QUICK QUACK CONSTITUTION  
GRADING PLAN  
2437 MARKSHEFFEL ROAD COLORADO SPRINGS, CO 80951

SHEET: C-2  
DATE: Jan 31, 2019

QUICK QUACK CONSTITUTION SWPPP PLAN

QUICK QUACK CONSTITUTION
SWPPP PLAN
2437 MARKSHEFFEL ROAD COLORADO SPRINGS, CO 80951

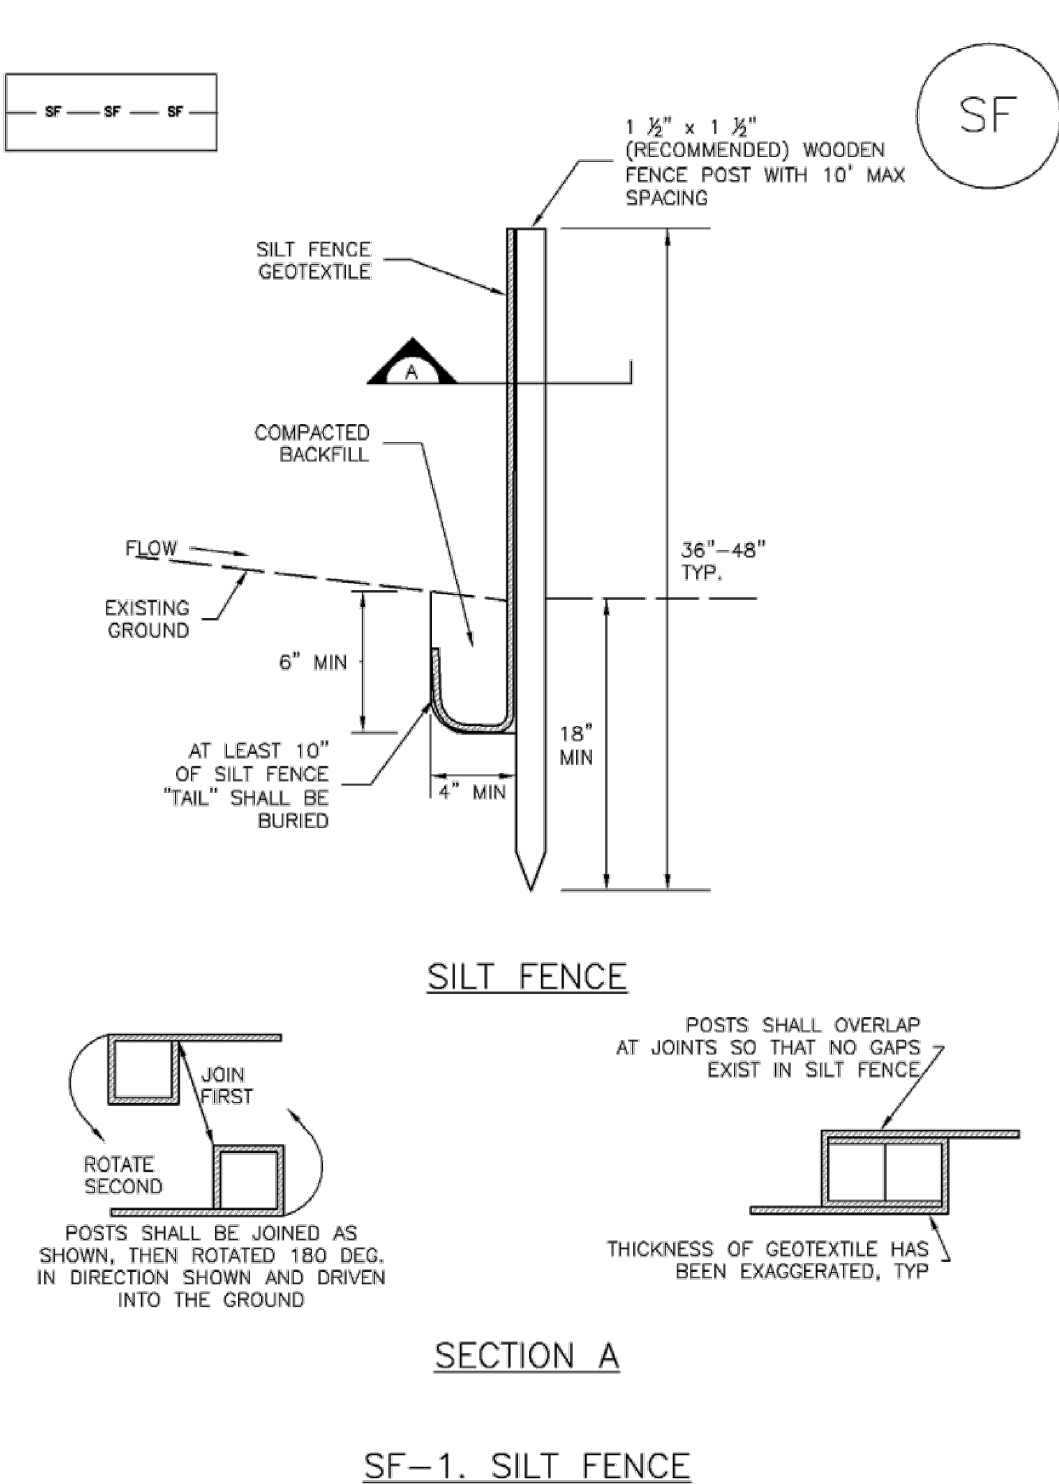
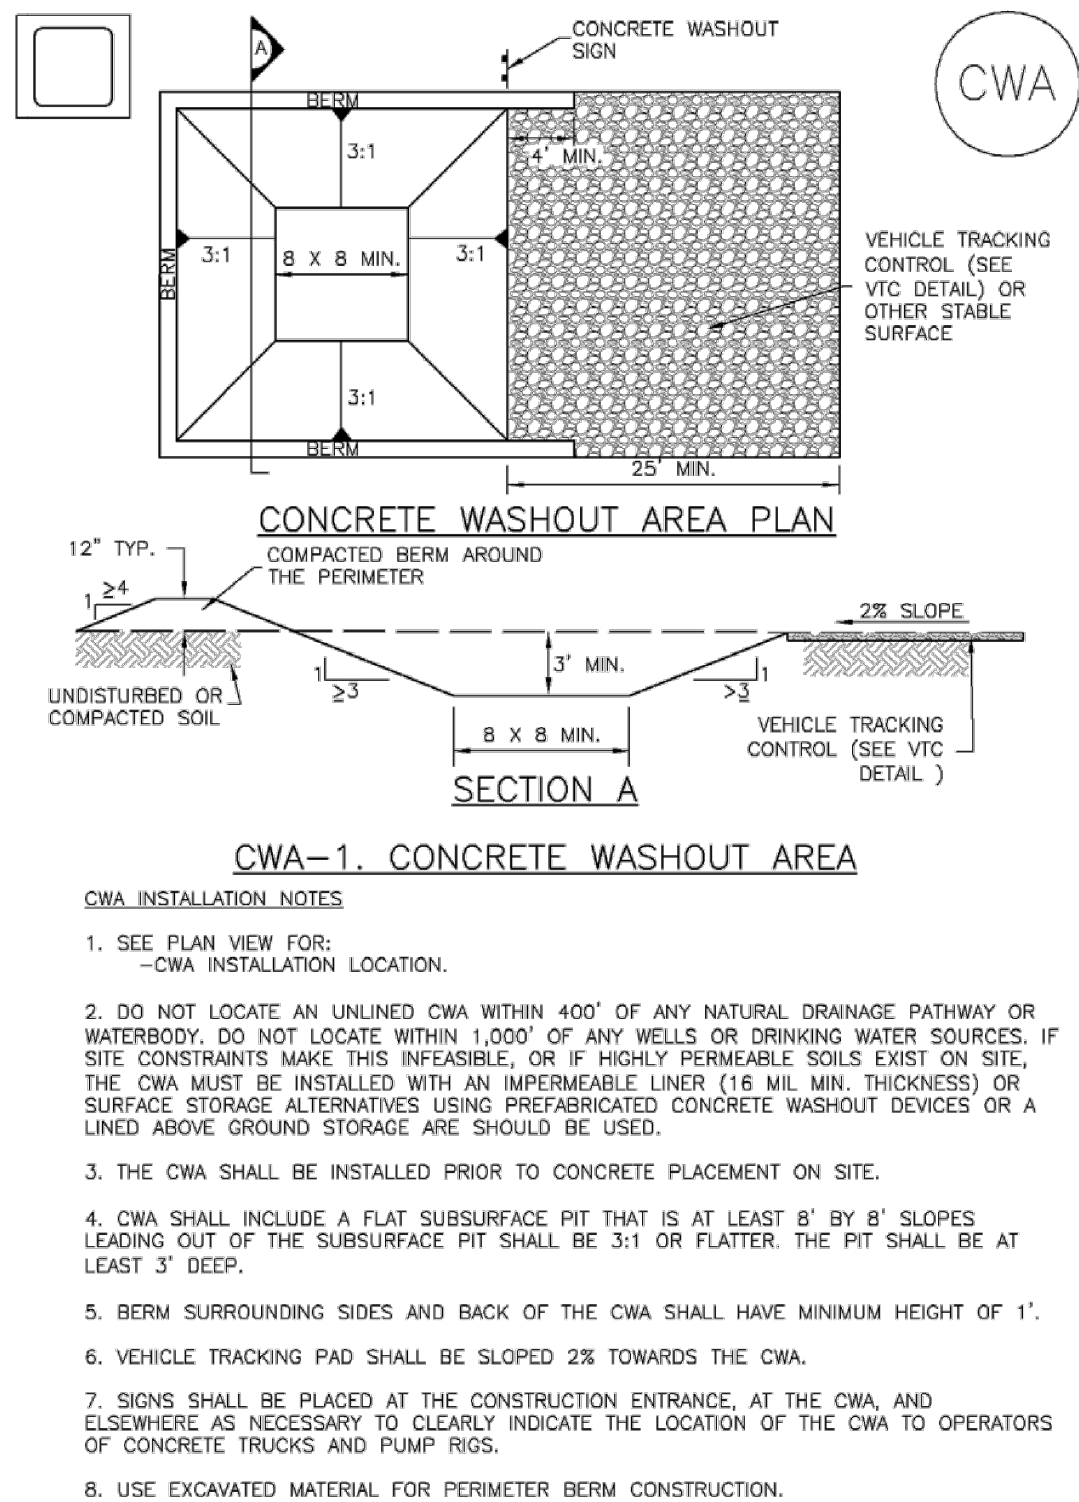
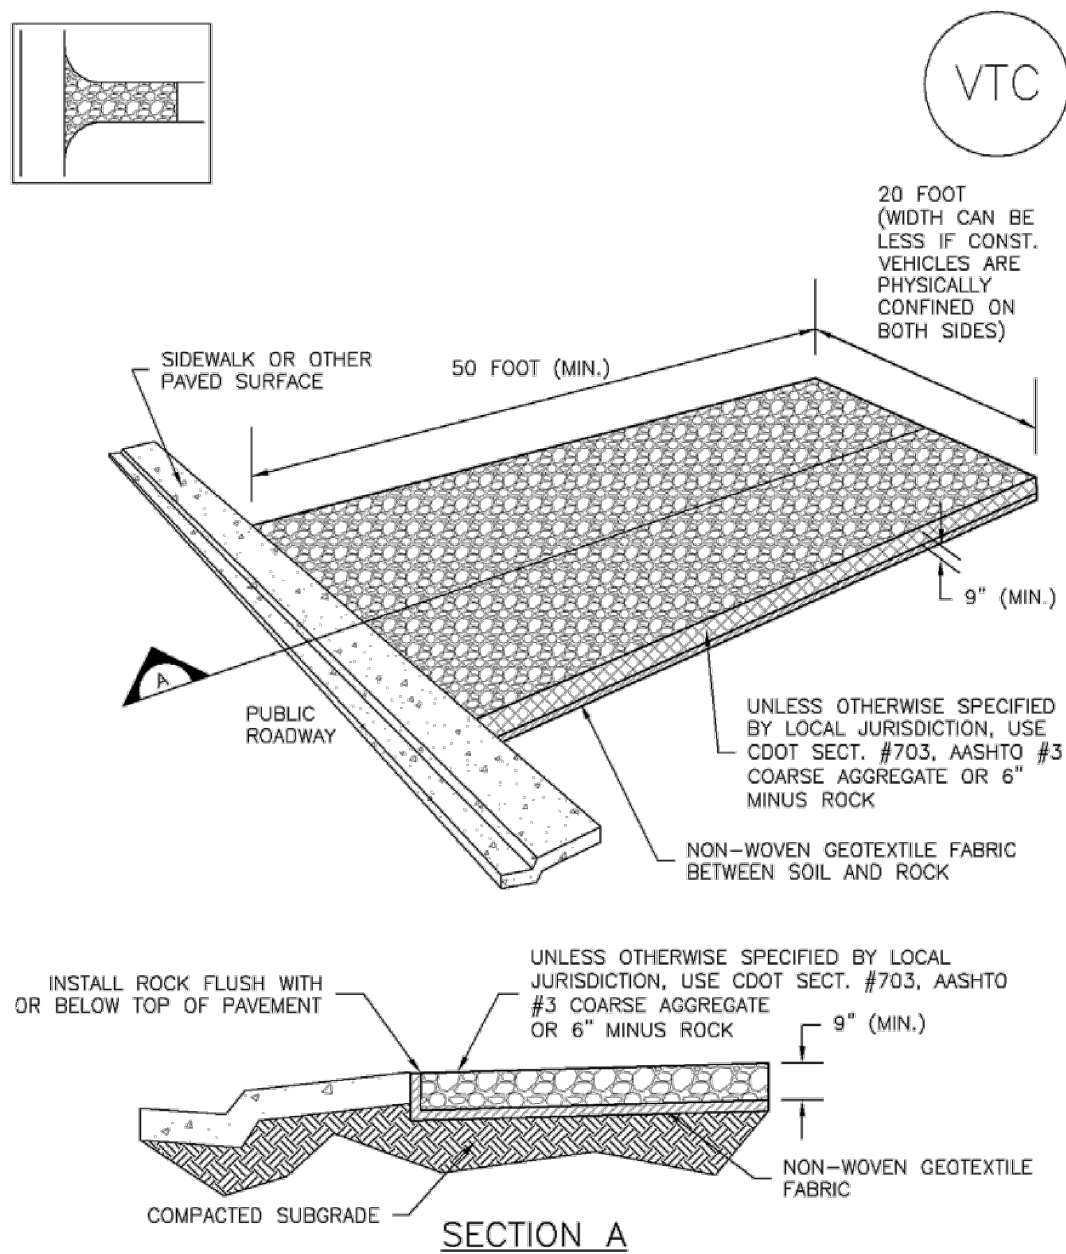
Replace with Erosion Control Details.  
SWPPP is not an acronym used in this area.
